RE: LAND AT LINESIDE INDUSTRIAL ESTATE NORTHWEST OF UNIT 26, ELDON WAY,
LITTLEHAMPTON

APPLICATION FOR NON-MATERIAL AMENDMENT TO PLANNING PERMISSION LU/275/19/PL

Drawing No.	Rev.
19005 - TP - 004	A

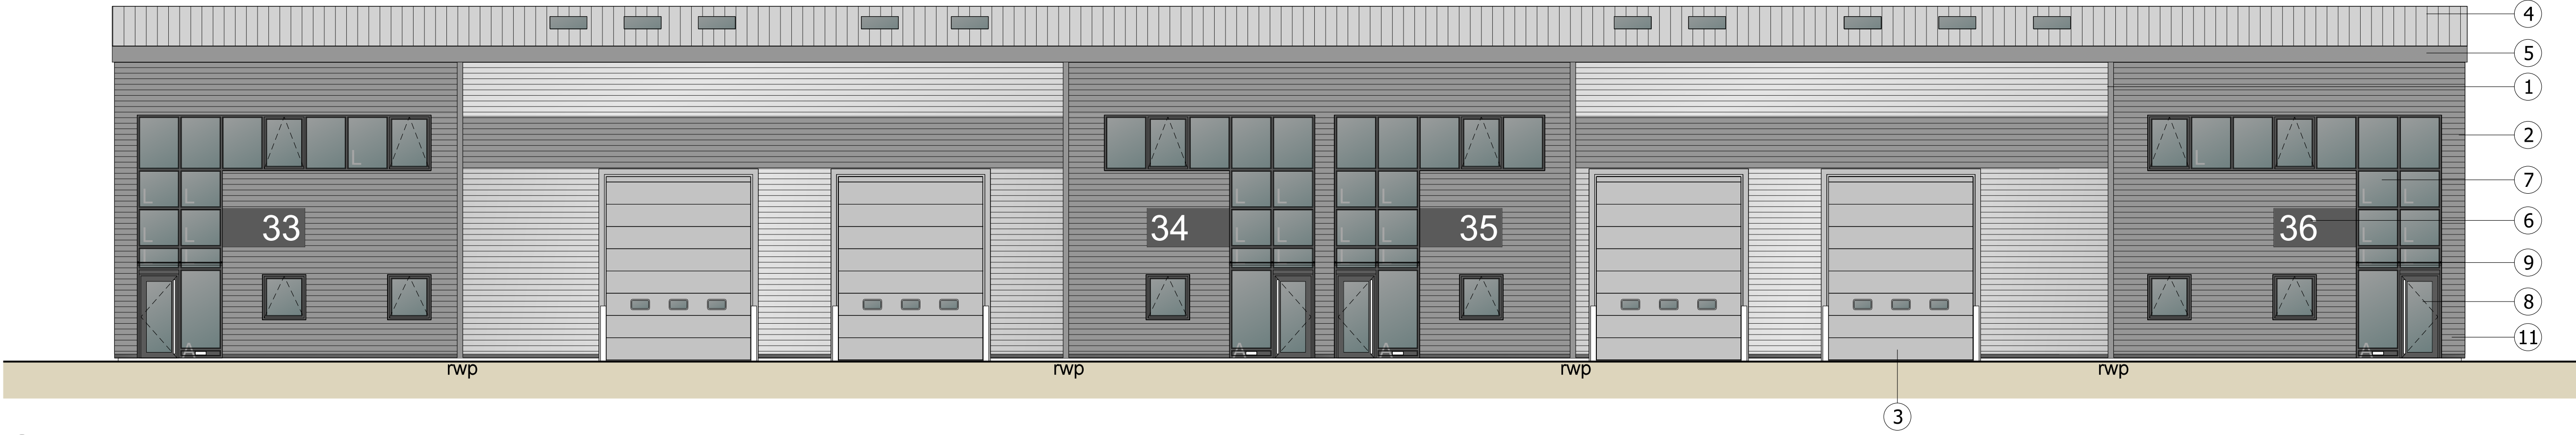
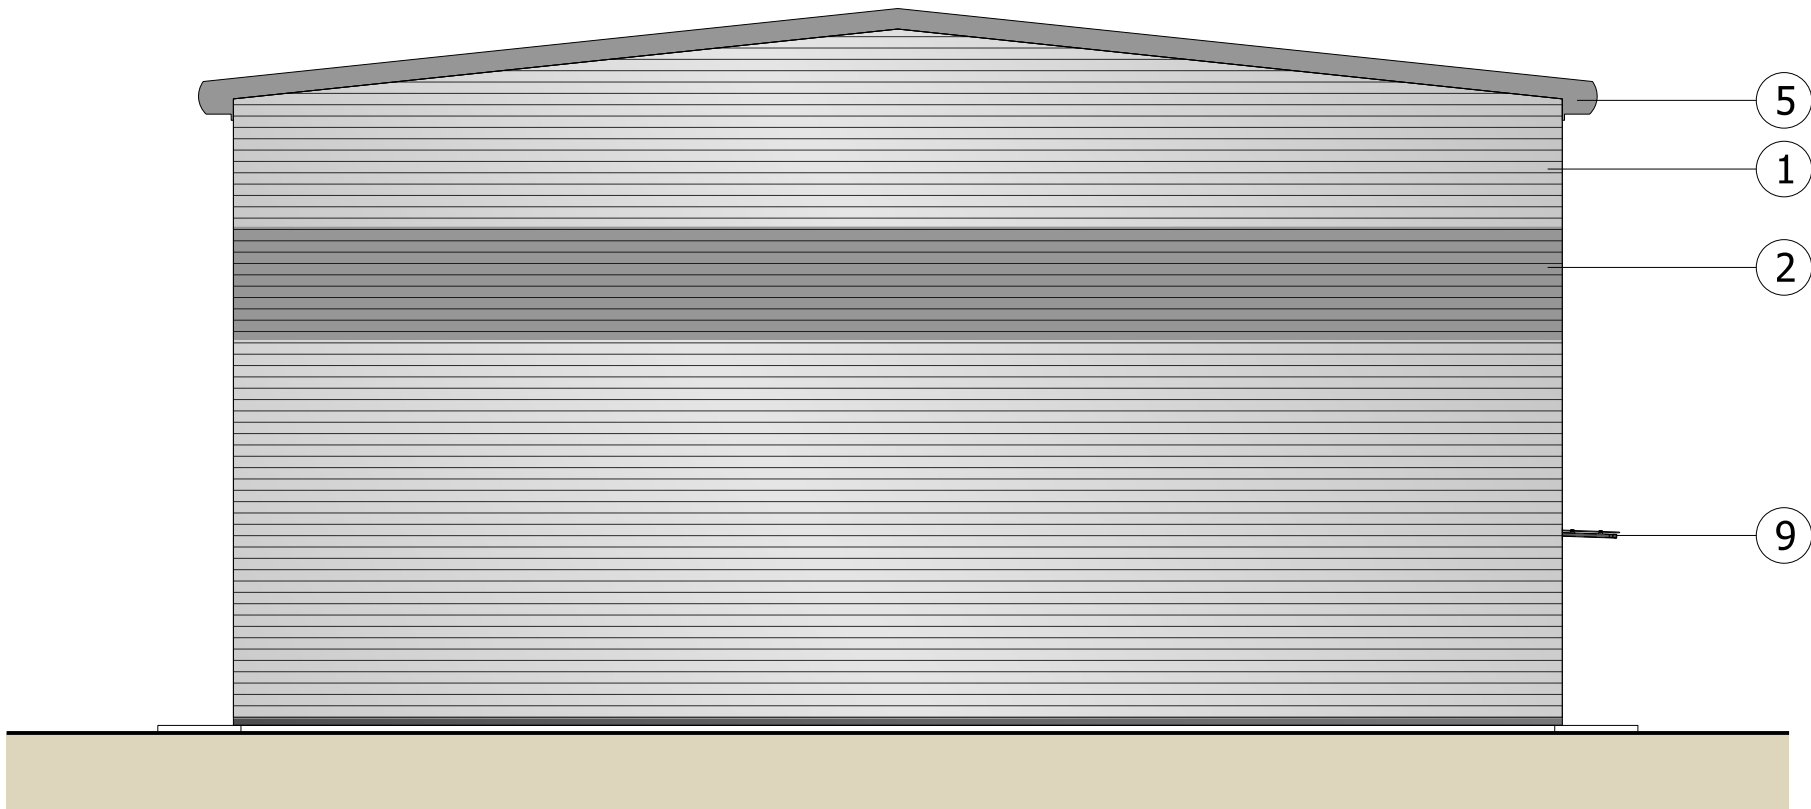
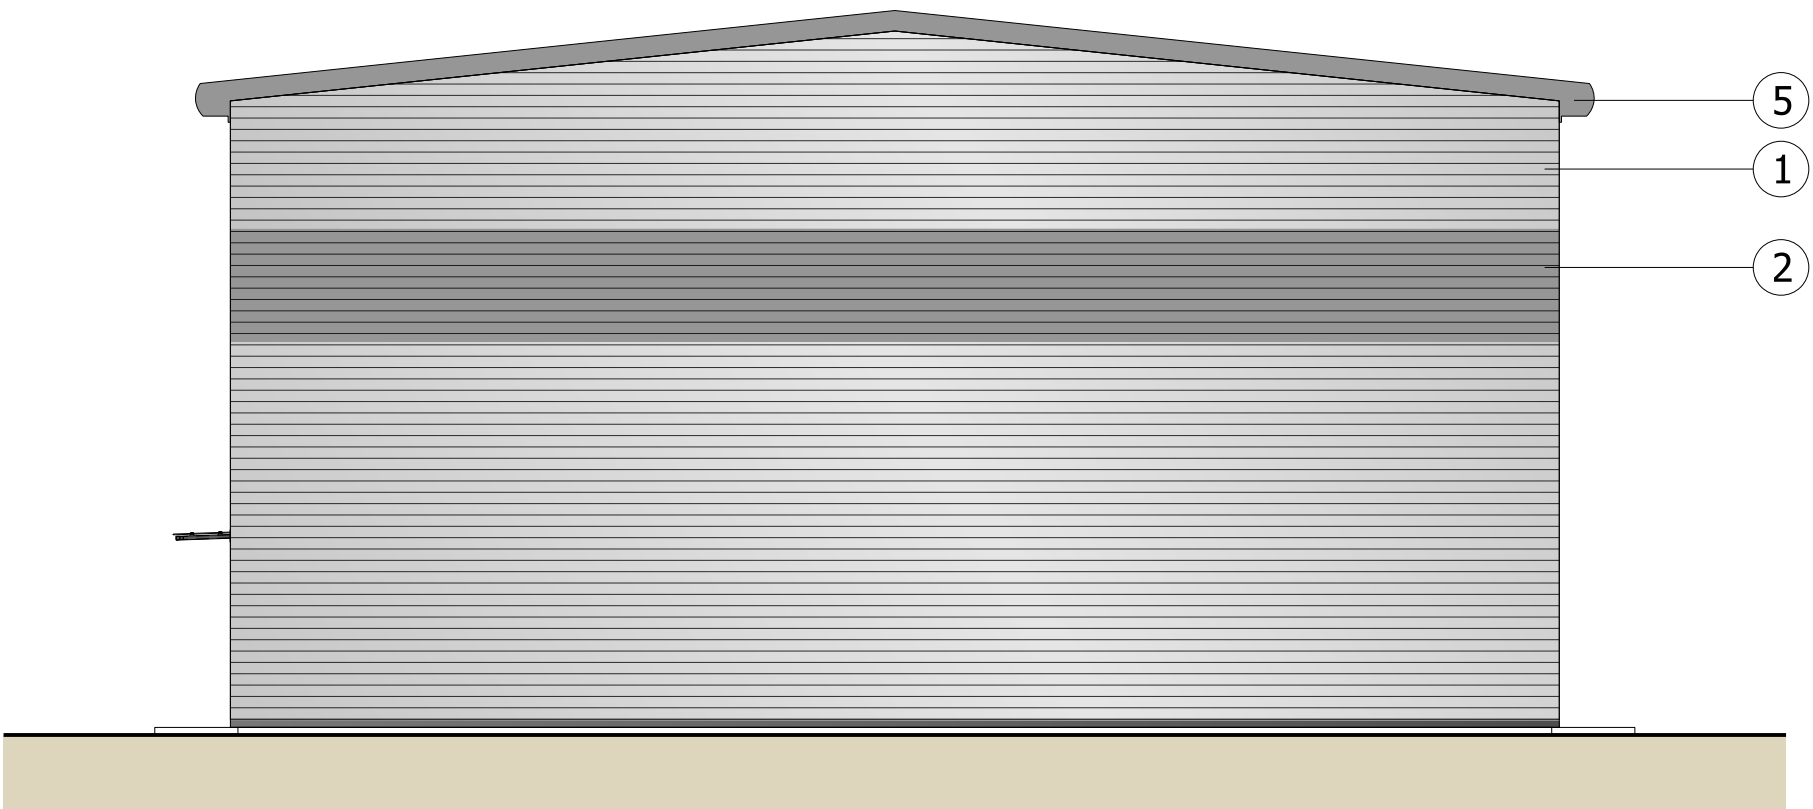
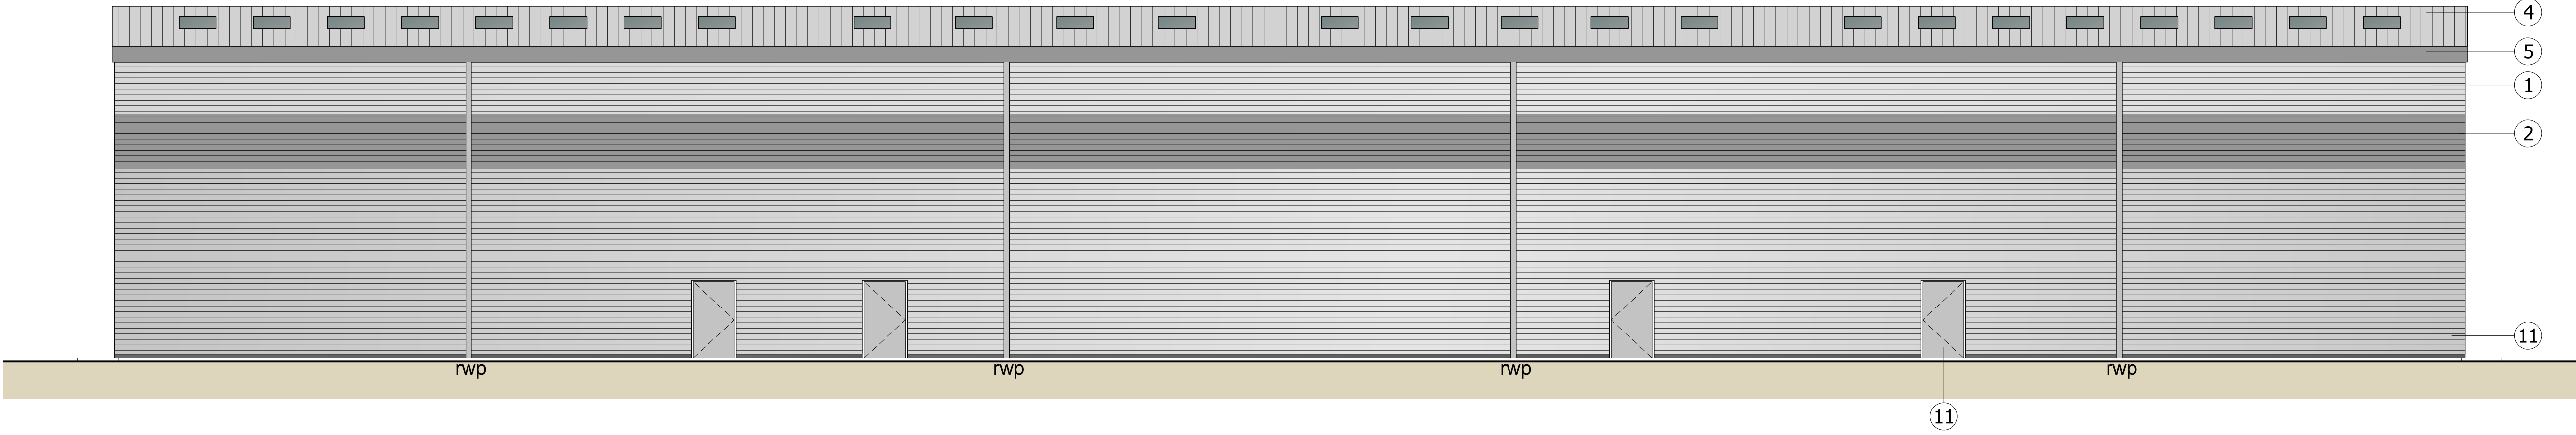
This application seeks to change a small area of hardstanding in the western part of the site to soft landscaping to align with the approved drainage strategy. This is presented in the updated Proposed Site Plan 19005-TP-002 Rev B which is intended to supersede the approved drawing 19005-TP-002 Rev A. Very minor changes are also proposed to the position of the downpipe so that it can be correctly integrated with the cladding that has been used. This is shown in the updated Elevations drawing 19005-TP-004 Rev A which is intended to supersede the approved drawing 19005-TP-004.
